From: [Jeremy B. Bell FAAV, FARLA, FLAA](#)
To: [A303 Sparkford to Ilchester](#)
Subject: A303 Sparkford to Ilchester Dualling Scheme Development Consent Order - Claimants A W Hewlett & Son and D W Hewlett
Date: 11 January 2019 09:36:51
Attachments: [Facebook40x40pixels_de448f6d-1702-43f3-abe1-21241b7d9ff6.png](#)
[LinkedIn40x40pixels_dd6f79a0-aae8-44df-827f-b47d48ab0a8e.png](#)
[Facebook40x40pixels_de448f6d-1702-43f3-abe1-21241b7d9ff6.png](#)
[LinkedIn40x40pixels_dd6f79a0-aae8-44df-827f-b47d48ab0a8e.png](#)
[Email_22nd_Dec_17_-_16.13.pdf](#)
[Email_22nd_Dec_17_-_18.02.pdf](#)
[Plans.pdf](#)
[Email_6th_Nov_17_-_14.20.pdf](#)
[Email_9th_Nov_17_-_10.27.pdf](#)
[Email_25th_May_18_-_10.41.pdf](#)
Importance: High

Claimants: **A W Hewlett & Son, Wales Dairy, Queen Camel, Yeovil, Somerset, BA22 7PB**
D W Hewlett, Blackwell Farm, Queen Camel, Yeovil, Somerset, BA22 7PB

On behalf of our above mentioned clients we wish to lodge an objection to the design scheme layout of the section either side of Eyewel Lane aka Traits Lane on the south side.

Figure 2.2 Main site compound.

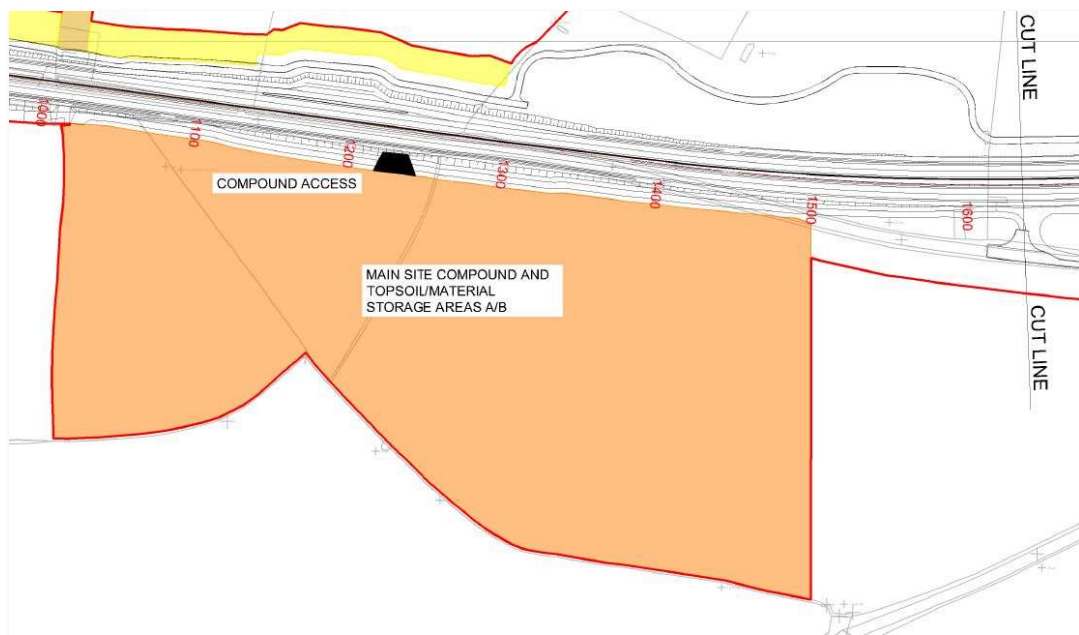
The area coloured purple plots 5/13b and 7/1b for a compound affects a huge swathe of land, which as has already been explained will have a huge impact on what is one of only two active livestock farms affected by the scheme. It simply cuts off their ability to administer the application of slurry on the land due to the nature and topography of the land and available hard road access.
